Re SSD 8804

I refer to the notification to the Environment Protection Authority (EPA) on 23 April 2020 from the Major Projects Portal about the State Significant Development 8804 proposing the expansion of operations at the existing Howlong Sand and Gravel Quarry at Howlong.

Attachment A

Noise Modelling Assessment

2.2.2 Noise contour map of quarry during Stage 2

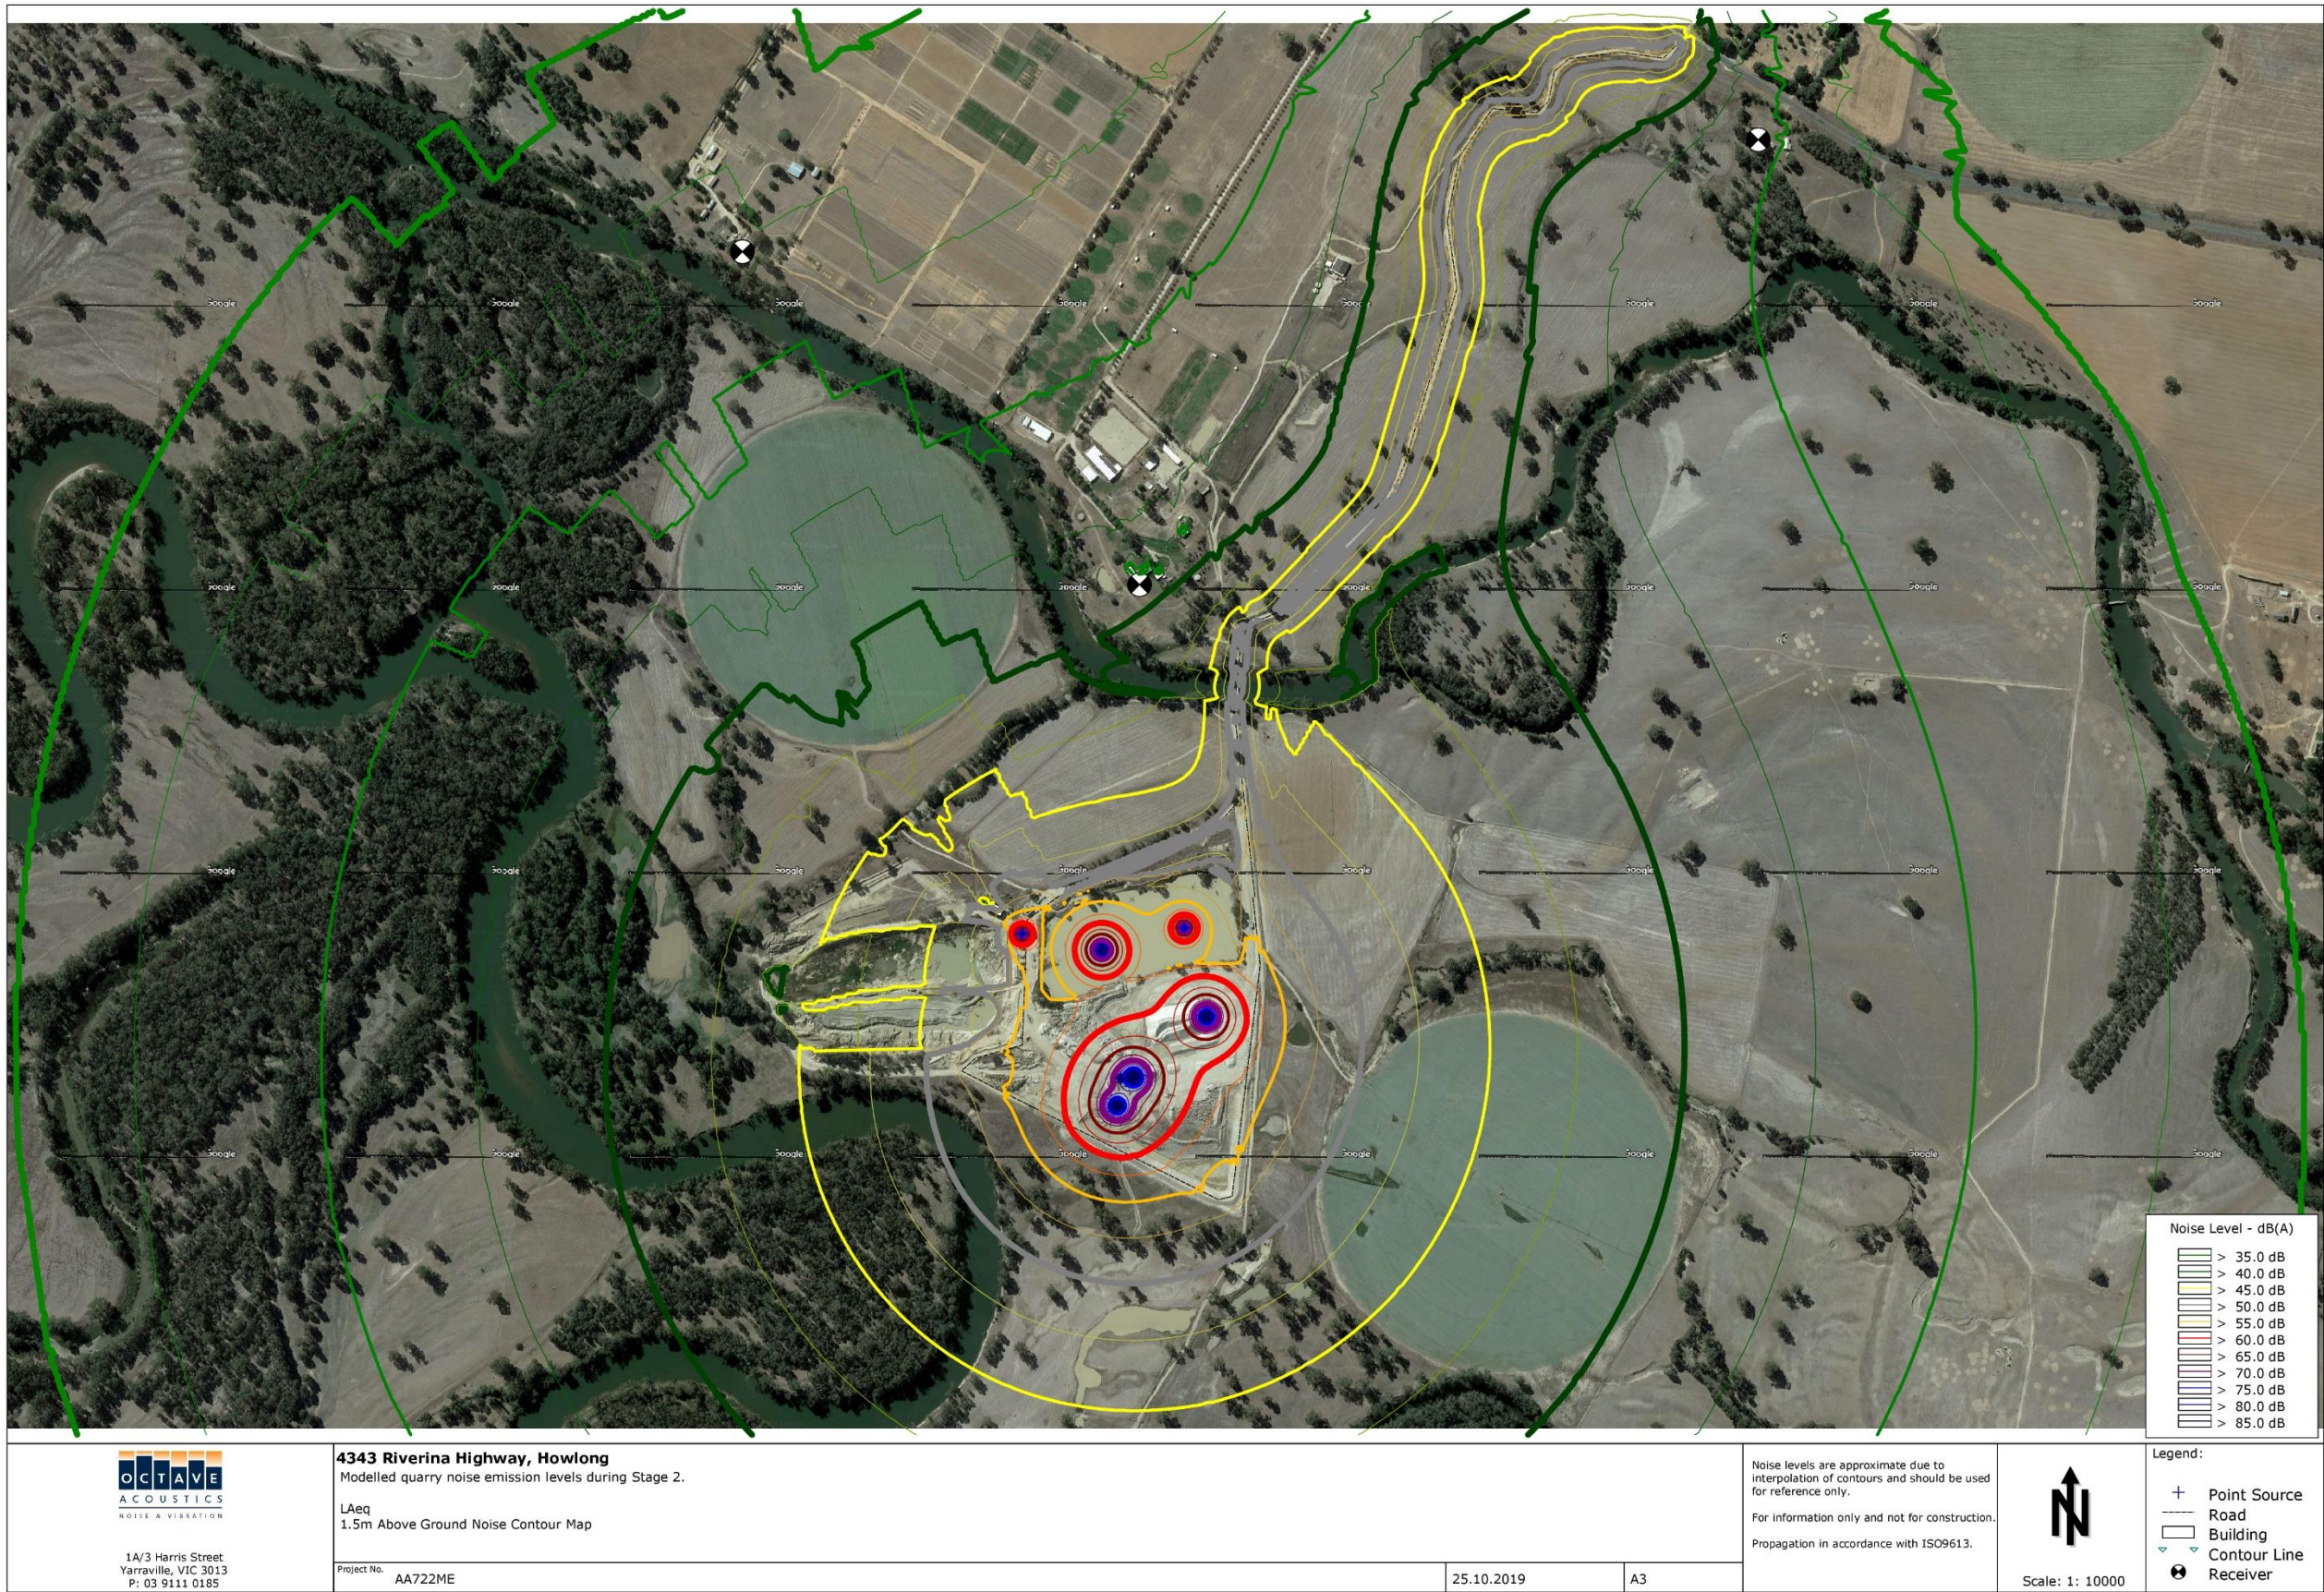
The Noise Modelling Assessment provides noise contour maps for Stage 2 of the proposal, however noise contour maps have not been provided for all the proposed stages of work.

We recommend that the proponent provide the noise contour maps for each stage of the work, not just for Stage 2.
